From: Anita Gardner
Sent: 08 November 2019 17:40
To: Euan Clark - Folkes Architects [REDACTED]
Subject: FW: Planning Consultation on LU/295/19/DOC

In respect of application for Discharge of Condition 10 – Construction Management Plan

APPLICATION NO: LU/295/19/DOC

Description of Works: Approval of details reserved by condition imposed under ref APP/C3810/W/18/3197149 (LU/162/17/PL) relating to Condition Nos 9 - landscaping, 10 - Construction Management Plan, 13 - vehicular visibility splays, 14 - pedestrian visibility splays, 16 - cycle parking and 18 - street lighting.

Construction Management Plan Layout

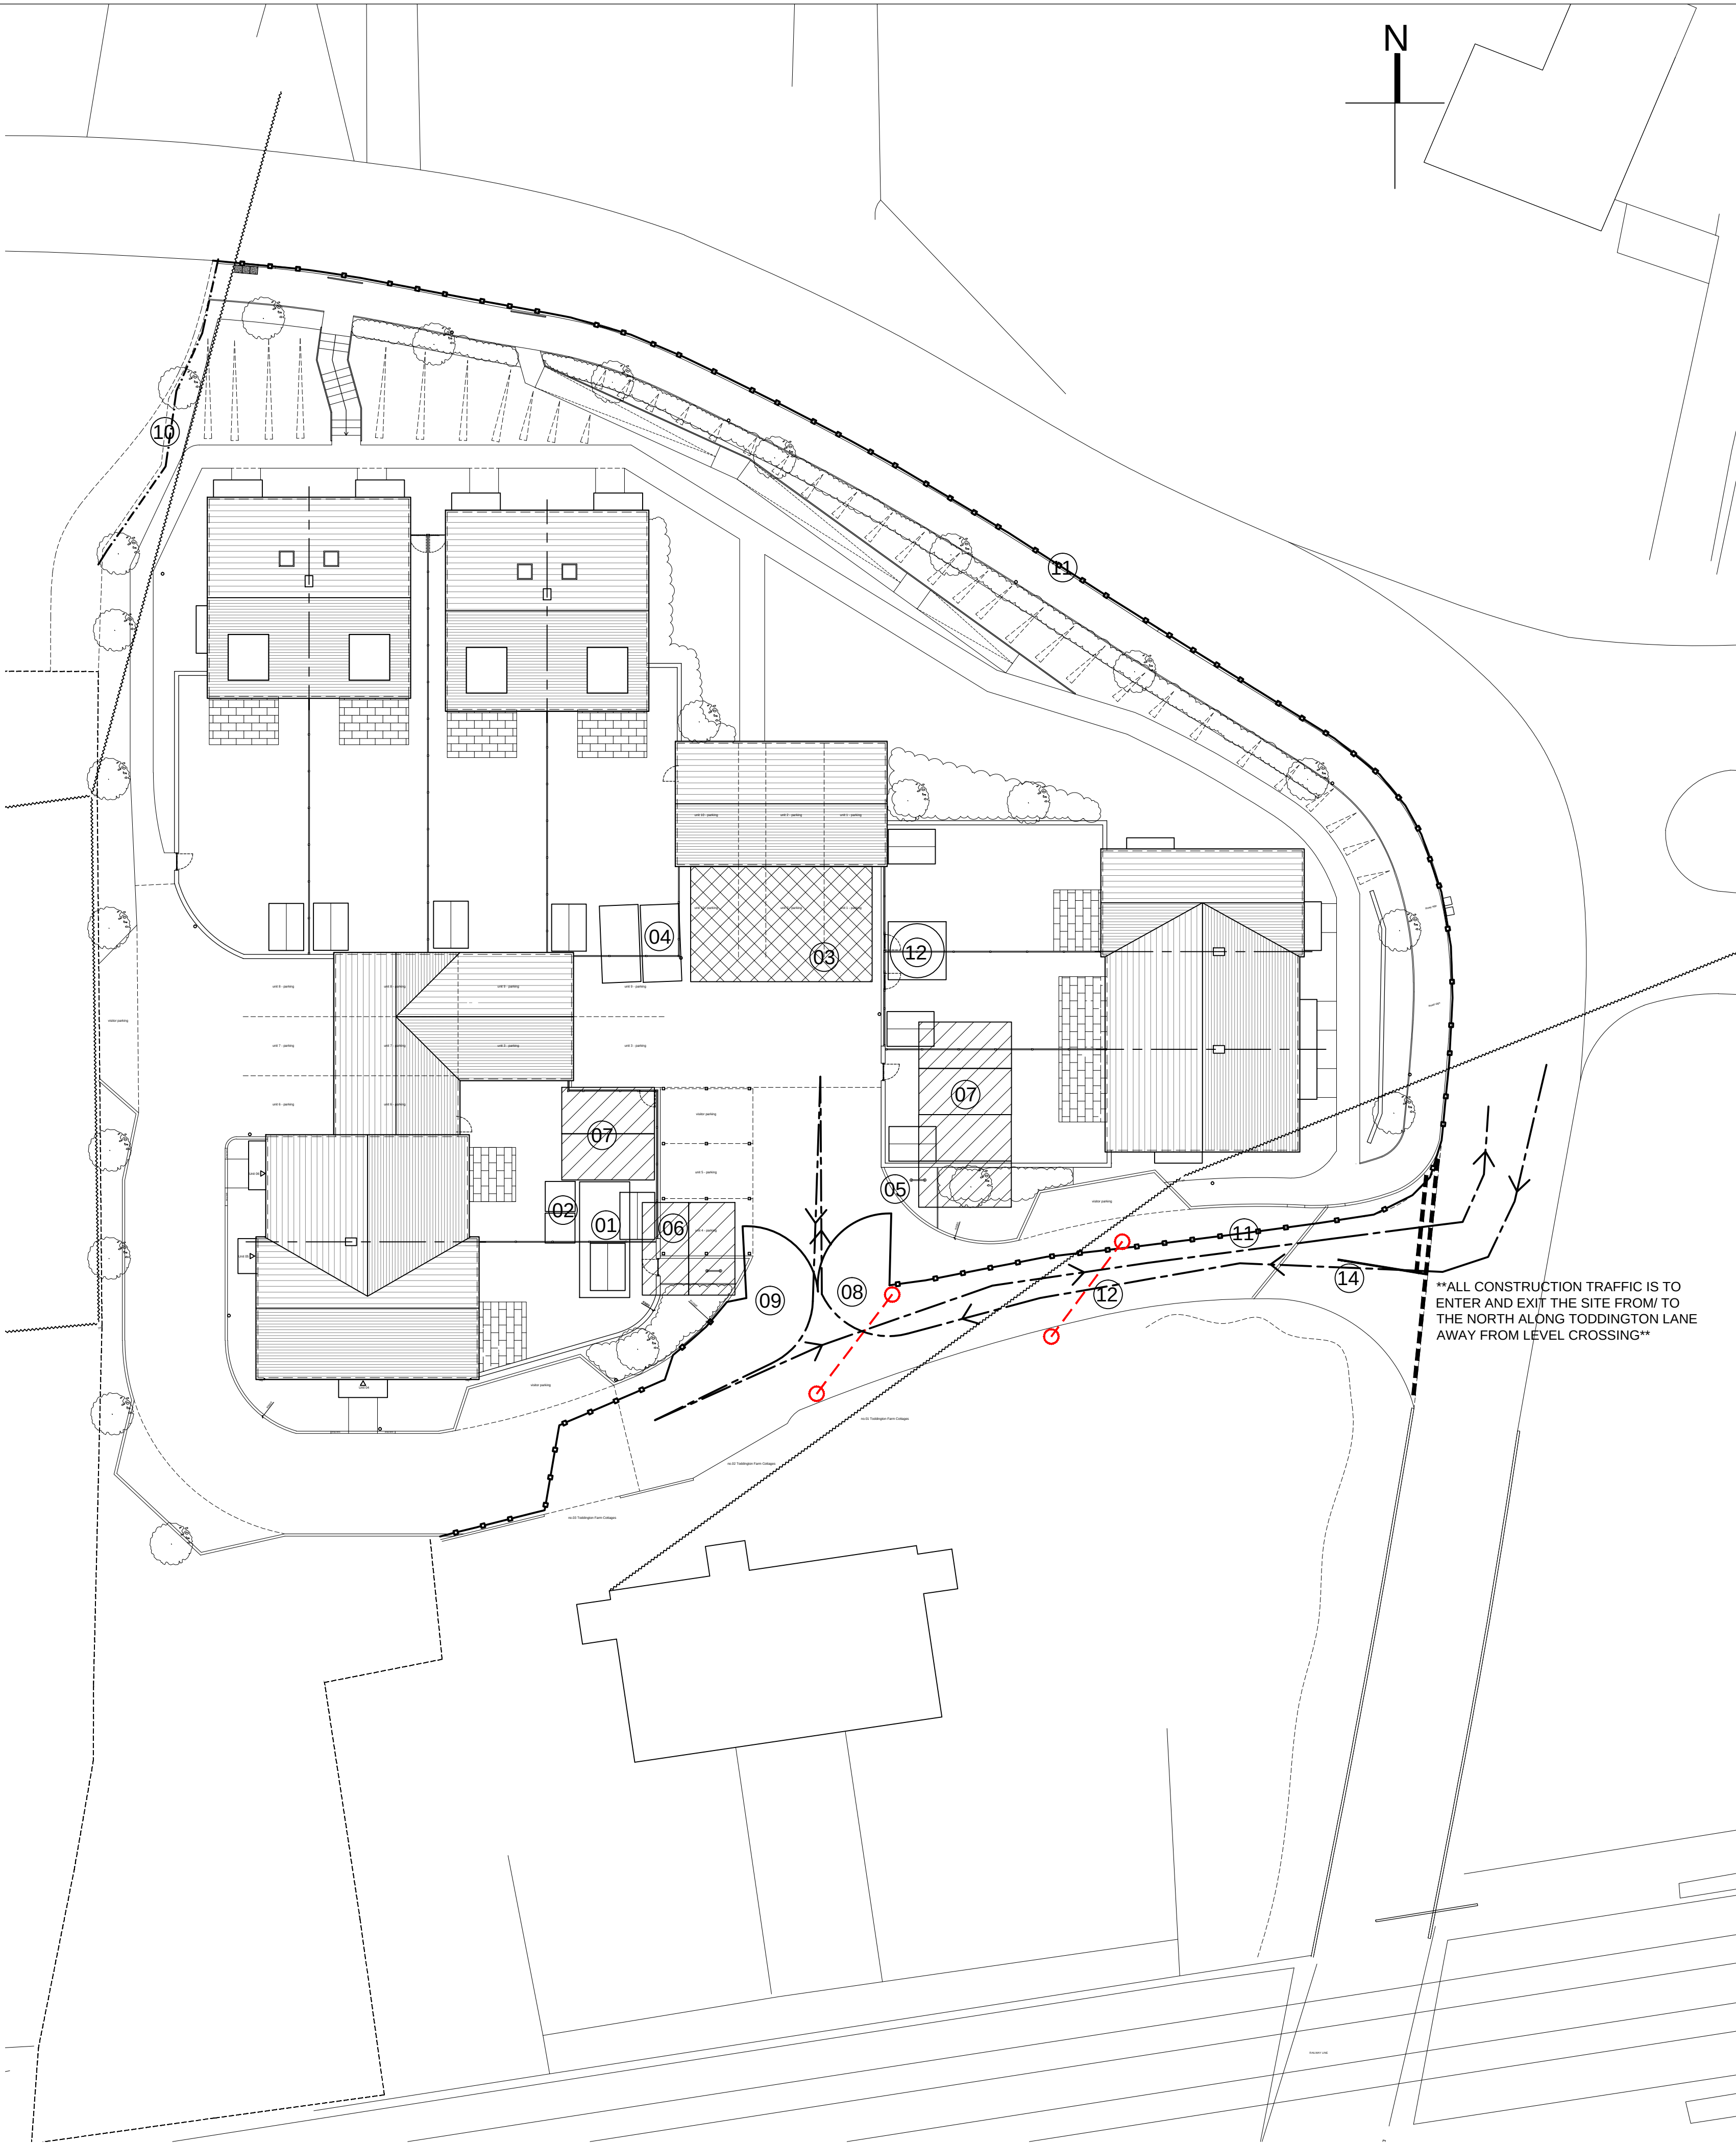
*Page 8, end paragraph 2.2. 'Materials stored in dedicated areas.' Please can the applicant provide a plan showing the intended location of such storage facilities.

DRAWING TITLE
Construction Management Plan Layout

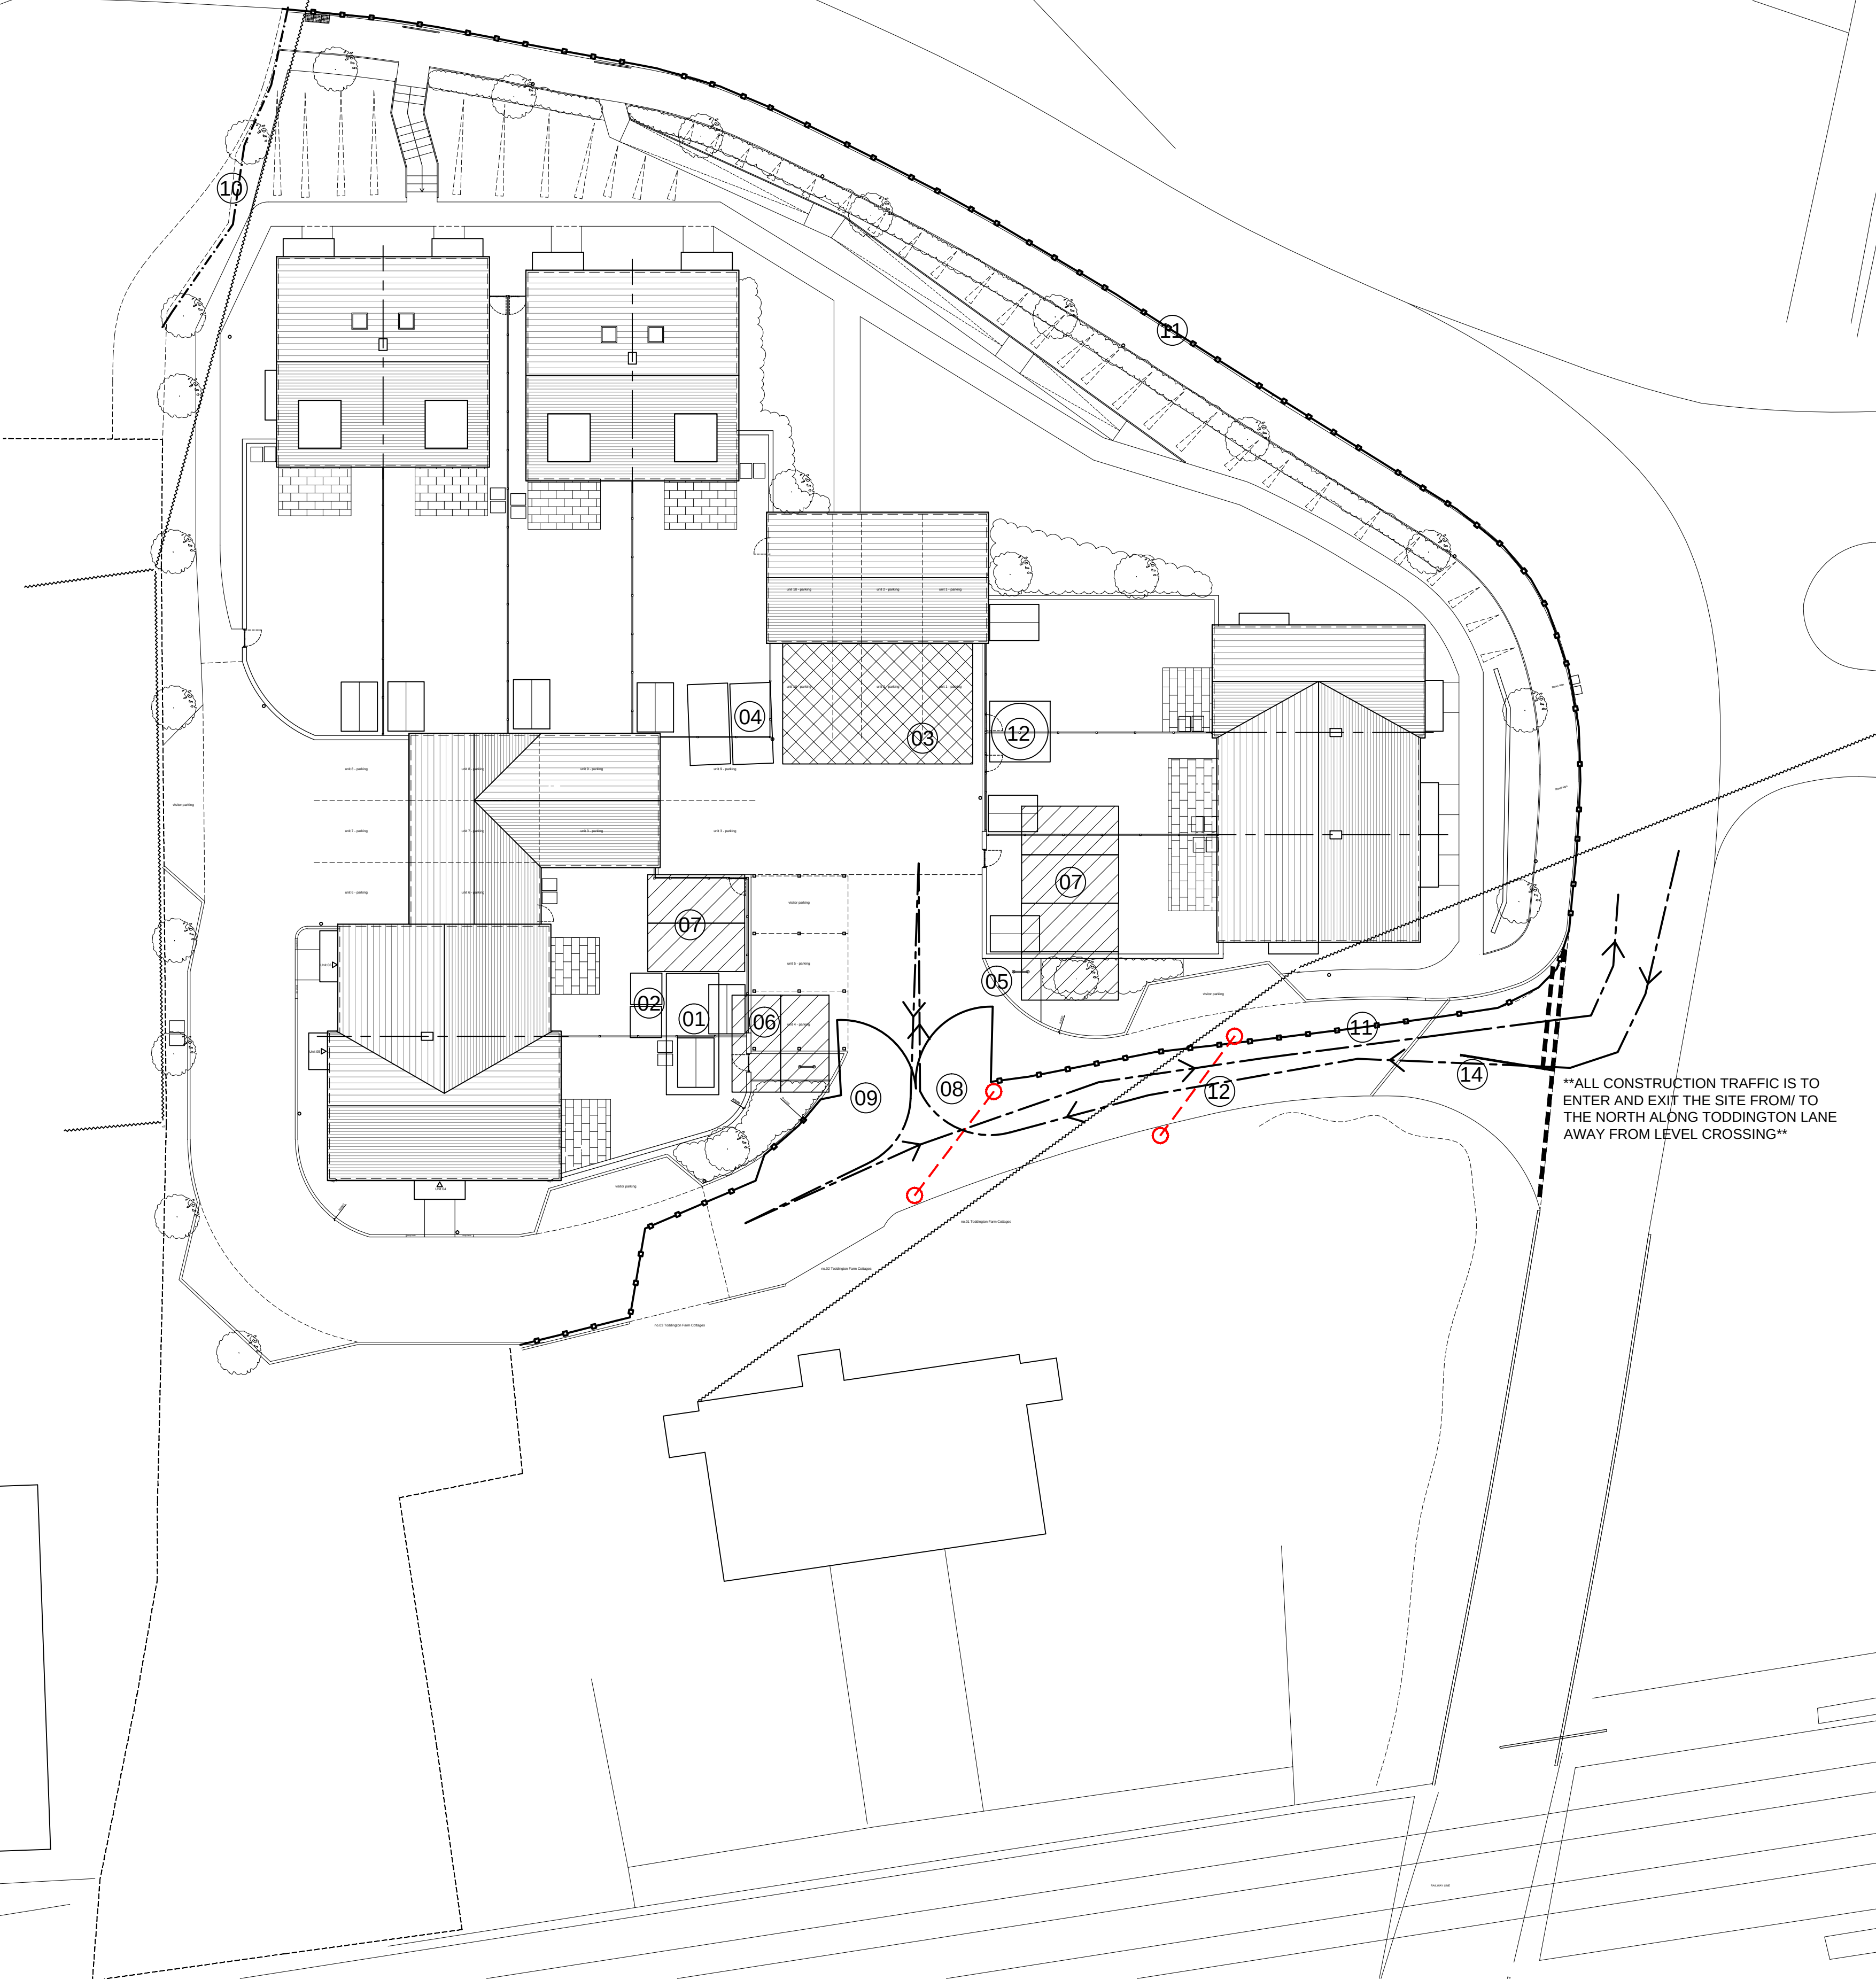
*Page 8, final paragraph. Please can the applicant provide the intended nearby location for holding delivery vehicles prior to arrival on site.
